**From:** sara@krdistrict.org  
**Sent:** Tuesday, January 21, 2025 11:28 AM  
**To:** Ellie Myers  
**Subject:** FW: BL-25-00003 Graaff - Notice of Application

RE: BL-25-00003

**TO:** All Staff  
**FROM:** Public Works Plan Review Team  
**DATE:** February 4, 2025  
**SUBJECT:** BL-25-00003 Graaff

GRAAFF PROPERTY

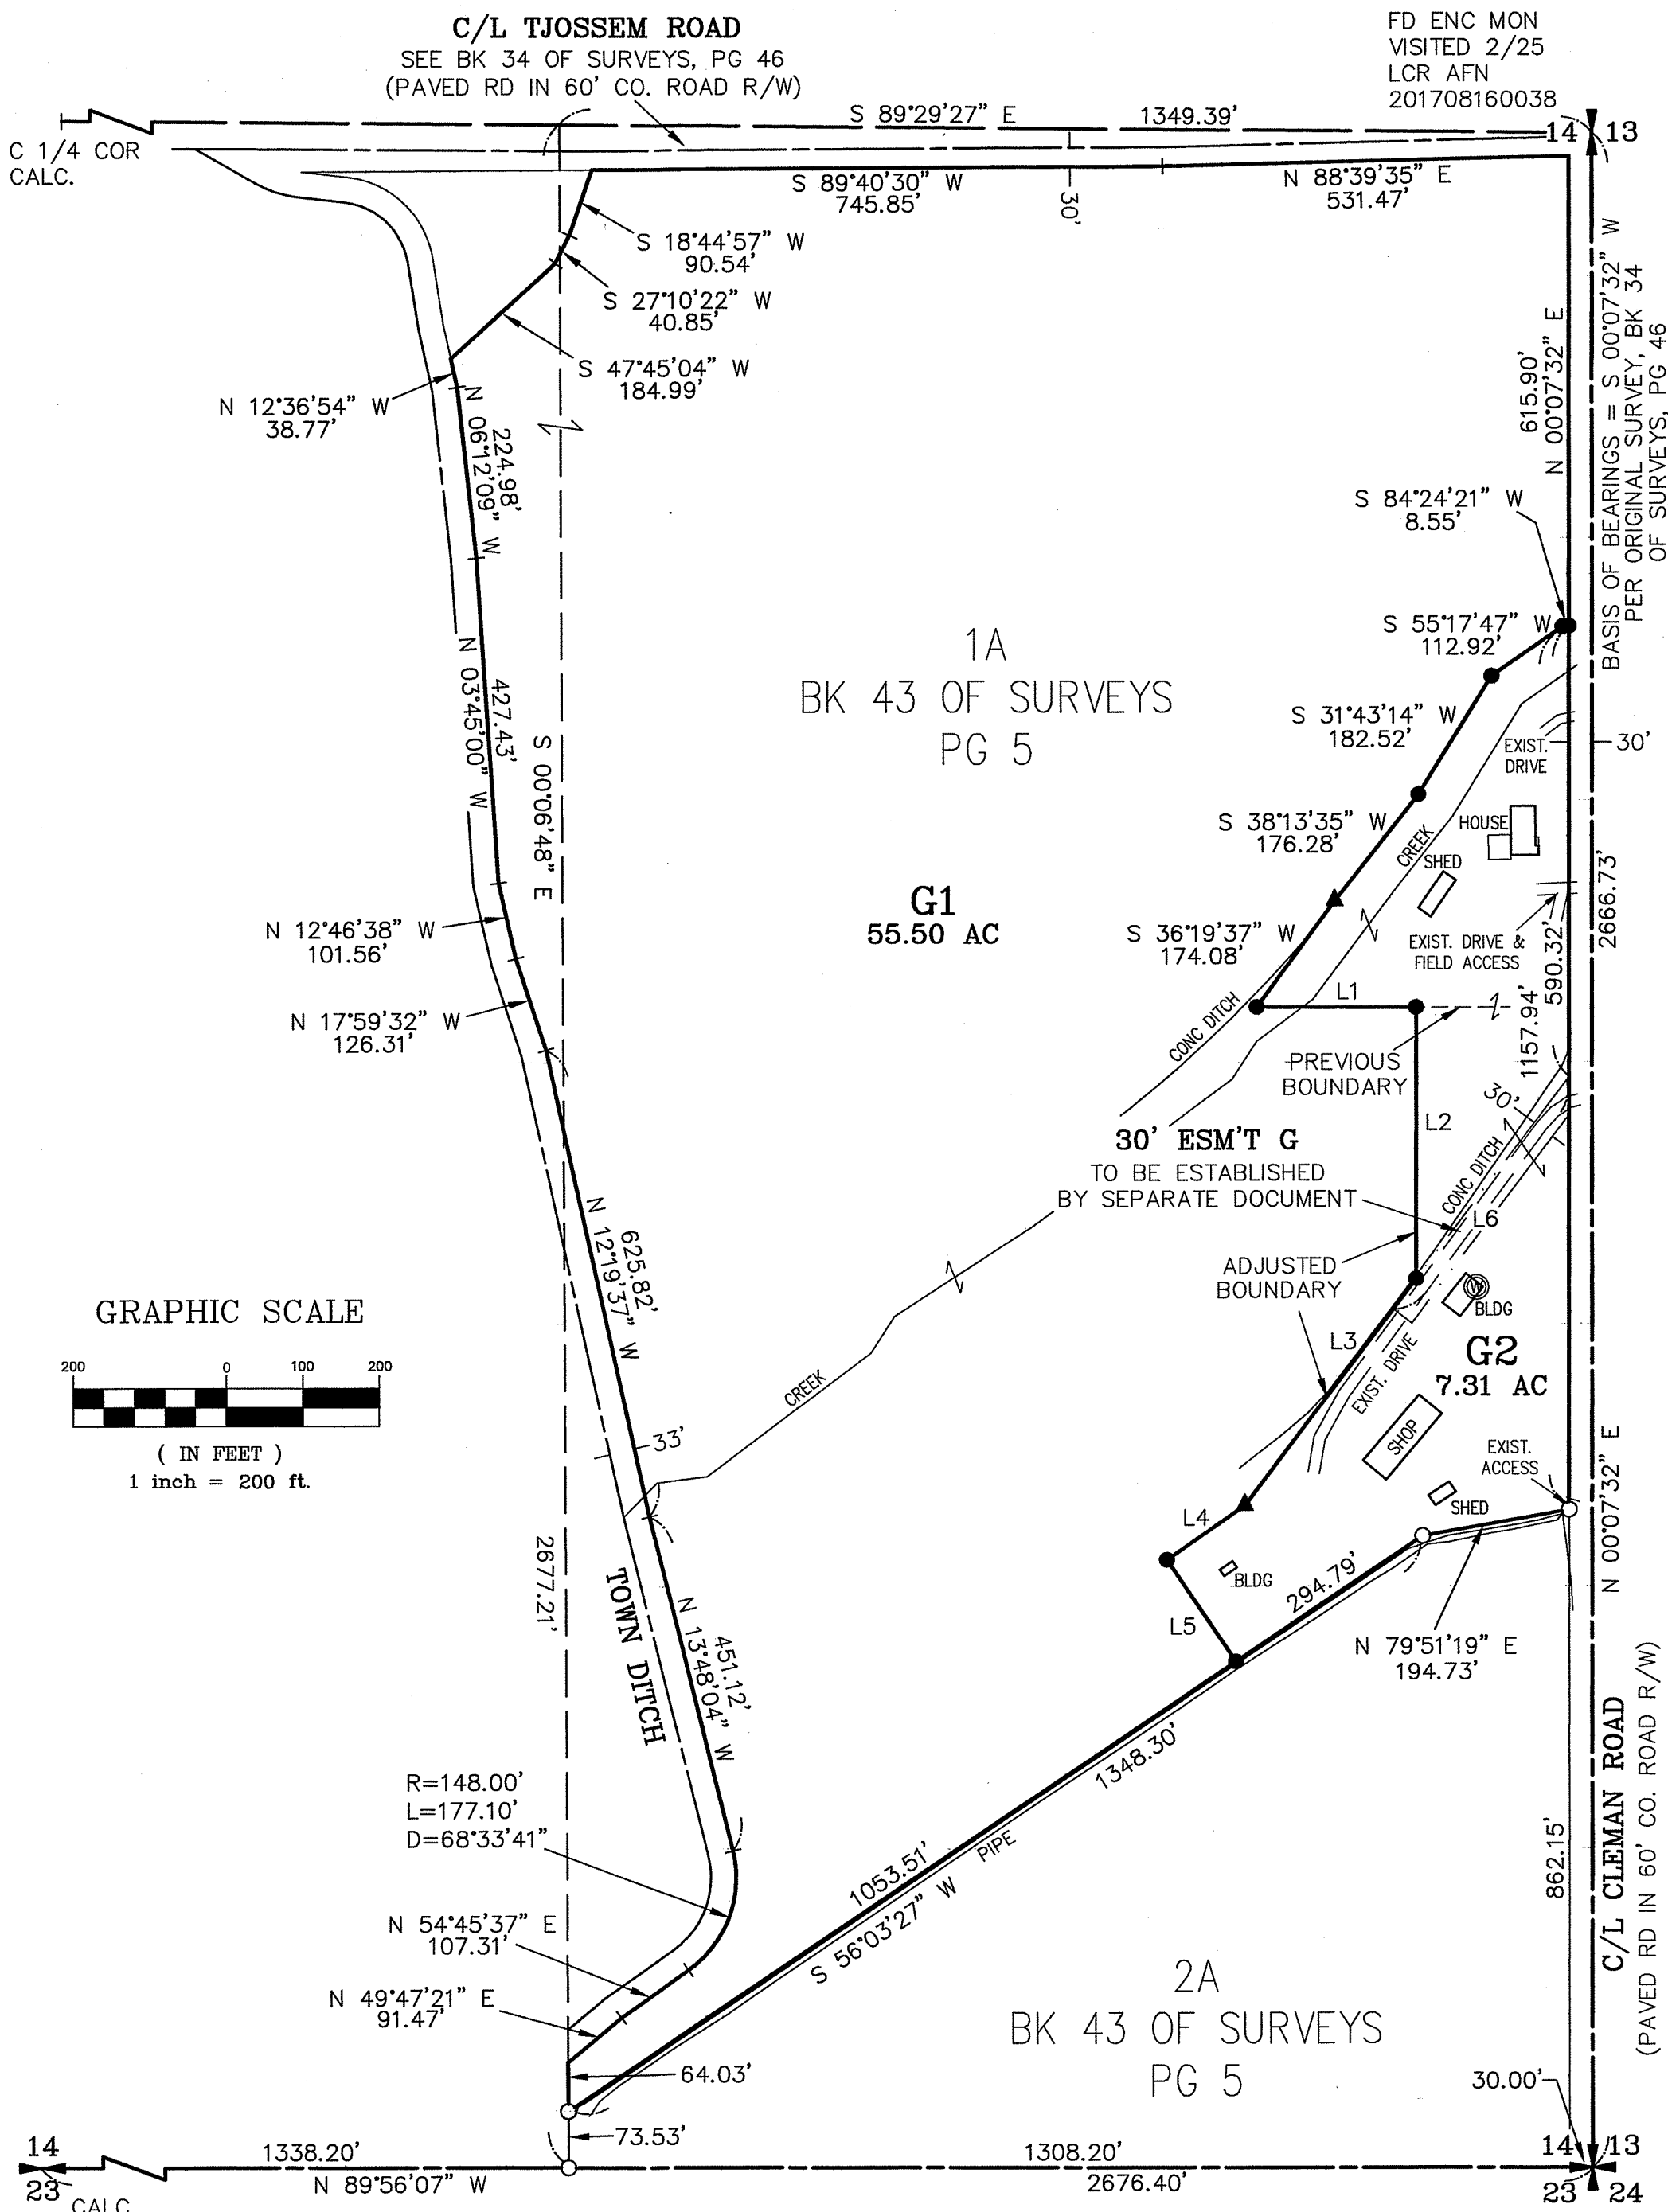
<b>ACCESS</b>	<ol style="list-style-type: none"><li>1. An approved access permit shall be required from the Kittitas County Department of Public Works prior to creating any new driveway access or altering an existing access.</li><li>2. KCC Title 12.04.07.050 states that residential lots have 1 access point. This newly created parcel will have 4 accesses, no additional accesses will be granted.</li><li>3. Maintenance of driveway approaches shall be the responsibility of the owner whose property they serve. The County will not maintain accesses.</li><li>4. Any further subdivision or lots to be served by proposed access may result in further access requirements. See Kittitas County Road Standards.</li></ol> <p>In addition to the above-mentioned conditions, all applicable Kittitas County Road Standards apply to this proposal. Access is not guaranteed to any existing or created parcel on this application.</p> <p><b>OFF NOTE:</b> Ensure the newly created parcel retains all 3 addresses assigned to parcels 370233 and 10184. Addresses 1171, 1191( Guest House?) 1421 Cleman Road.</p>

<b>FLOOD</b>	<p>A portion of the proposed parcels are within the 100-year floodplain boundary. If possible, any future development should remain outside of the floodplain in order to reduce risk and avoid mandatory flood insurance purchase requirements. All activities within the floodplain must be permitted through the floodplain development permit process and follow the regulations within KCC 14.08.</p> <p>While not required by KCC 14.08.220, it is highly encouraged that the floodplain boundaries are outlined on the face of the recorded survey. (SC)</p>
<b>WATER MITIGATION/ METERING</b>	No comments. (SC)
<b>AIRPORT</b>	No comments. (JS)
